From: Peterson, Dana M.
Sent: Thursday, June 28, 2018 10:54 AM
To: Wolfenbarger, Jeanne
Cc: Roeder, James A.
Subject: RE: JTH Estates #654887

**Re: Juan Tabo Hills Estates-
Revised Sheet 61R
Hydrology File-M21D018; DRB 1005278; CPN 654887**

SUMP INLET CALCULATIONS
For
Cattle Guard Grate at Blue Ribbon Road
(Juan Tabo Hills Estates, CPN 654887)

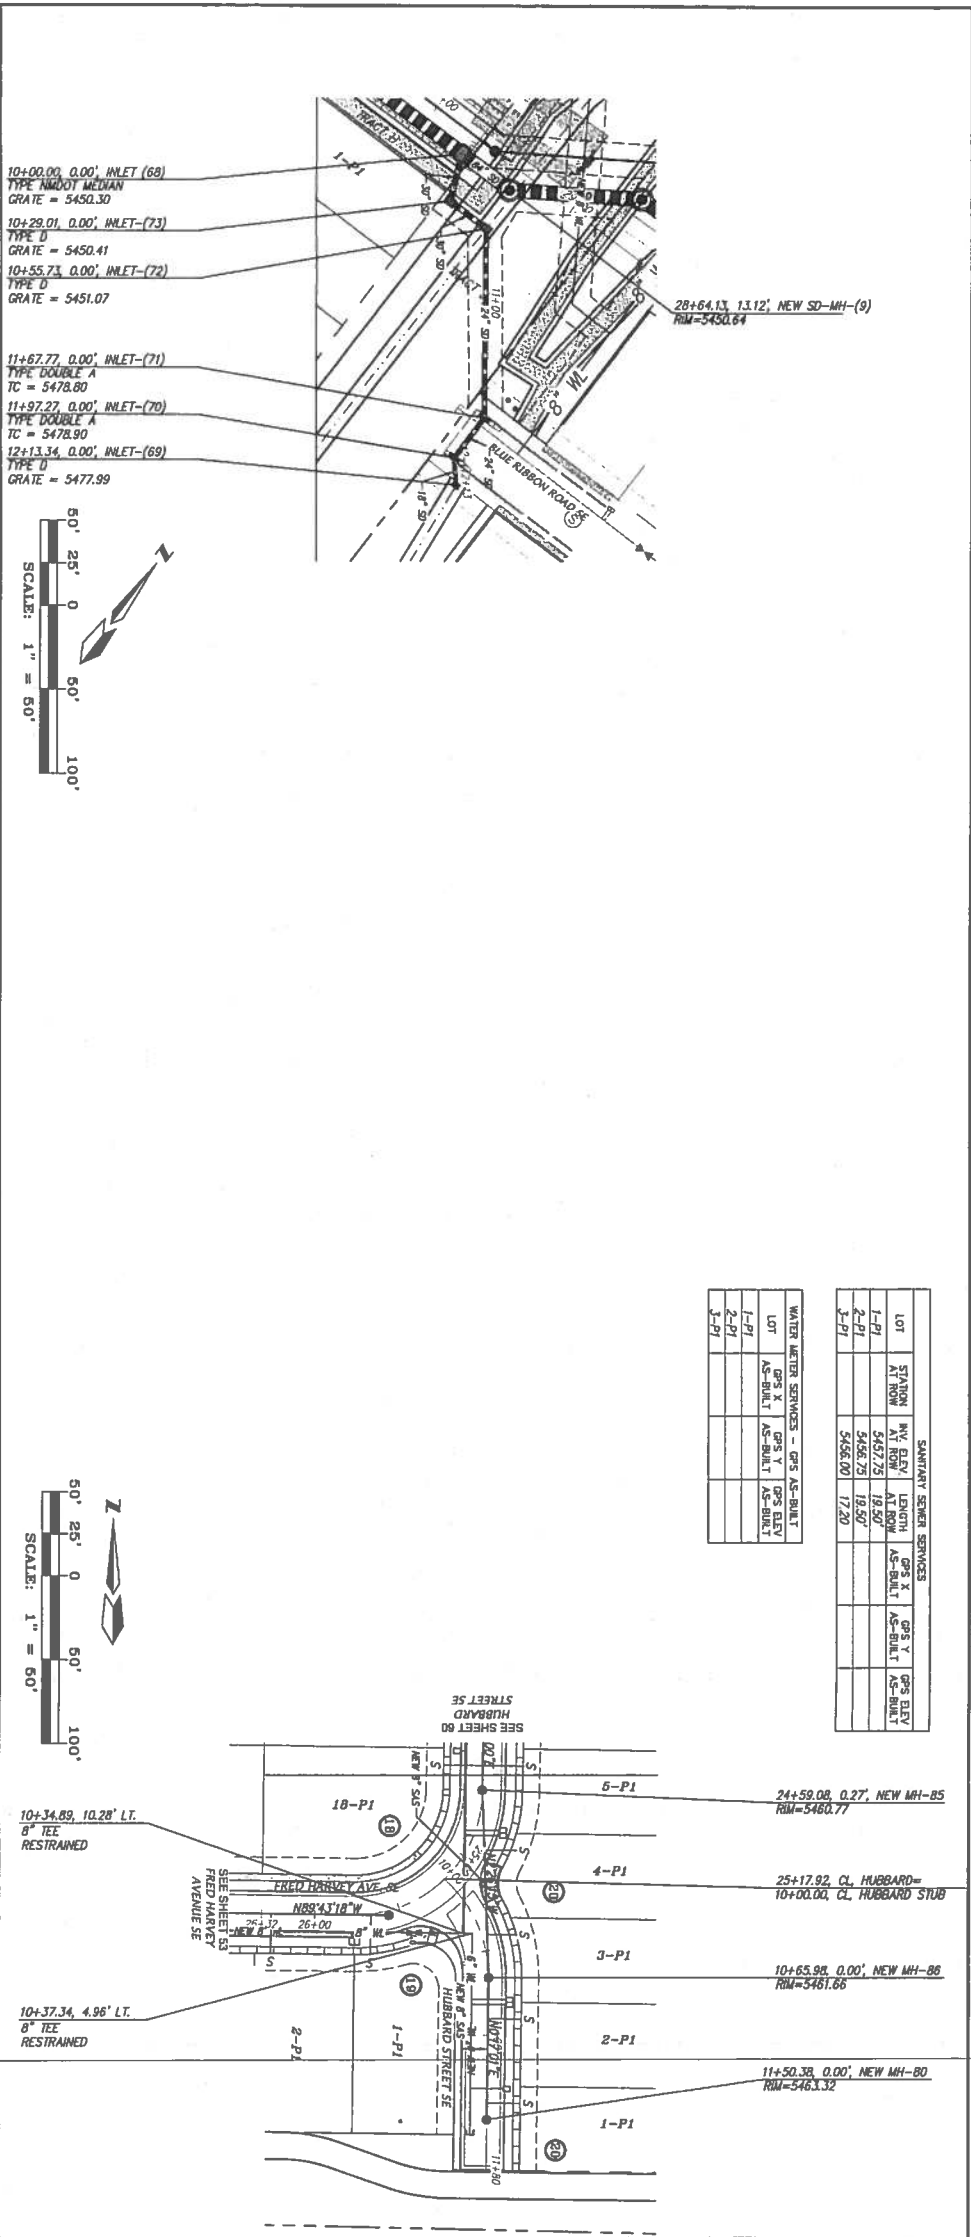
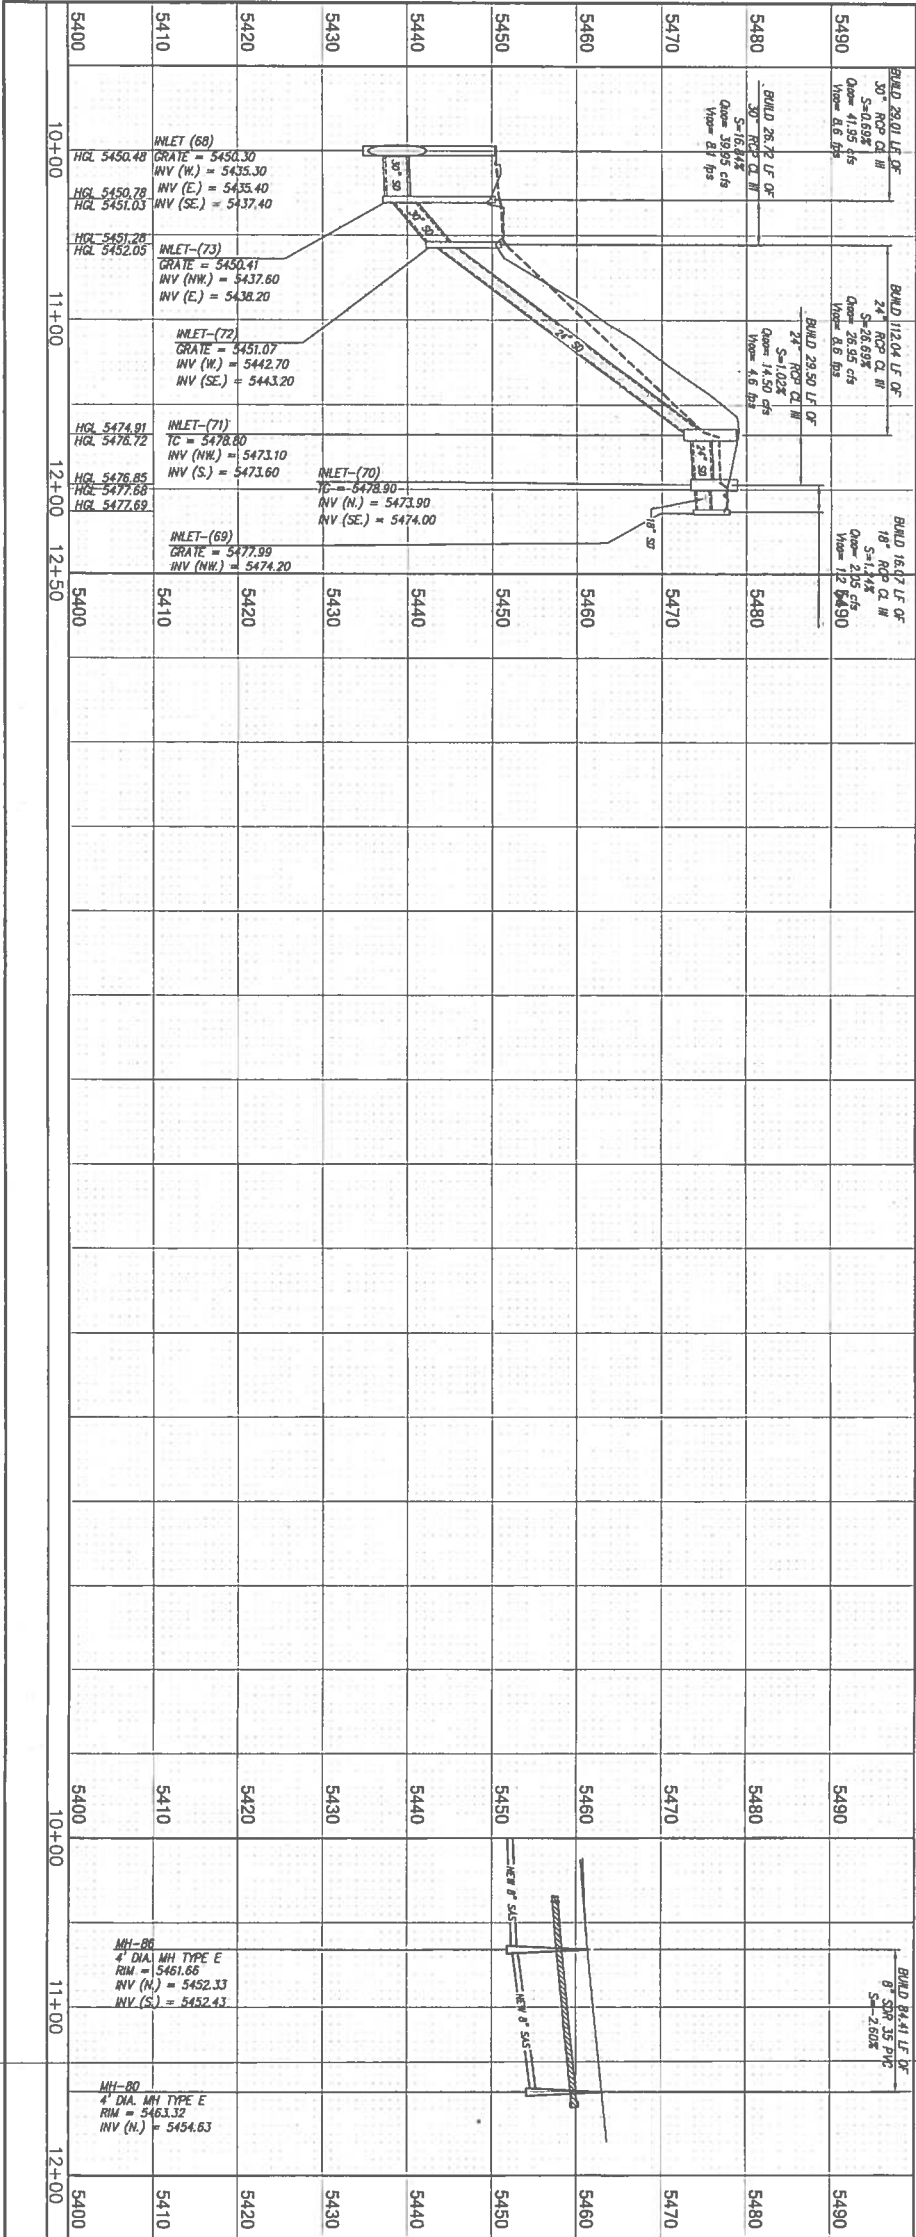
- The revision from two double-A inlets two double-D inlets needs to be supported with calculations demonstrating 2x 100-yr capacity for inlets in a sump using both the orifice and weir calculations.
- The change in inlet type should be noted in the change order request.
- Please put the HGL on the profile on sheet 61R.
- Please note that Easement R will need to be updated on the Final Plat to reflect the new storm drain alignment.

The referenced calcs and sheet 61R, stamped 6/26/18 are acceptable to Hydrology.

1. The double D inlets have been revised to a cattle guard grate that spans the roadway width. Only the weir equation calculation is necessary for this situation. The weir has almost 2 times the 100 year storm capacity, which should be adequate.
2. Okay.
3. Okay,
4. The final plat has already been revised.
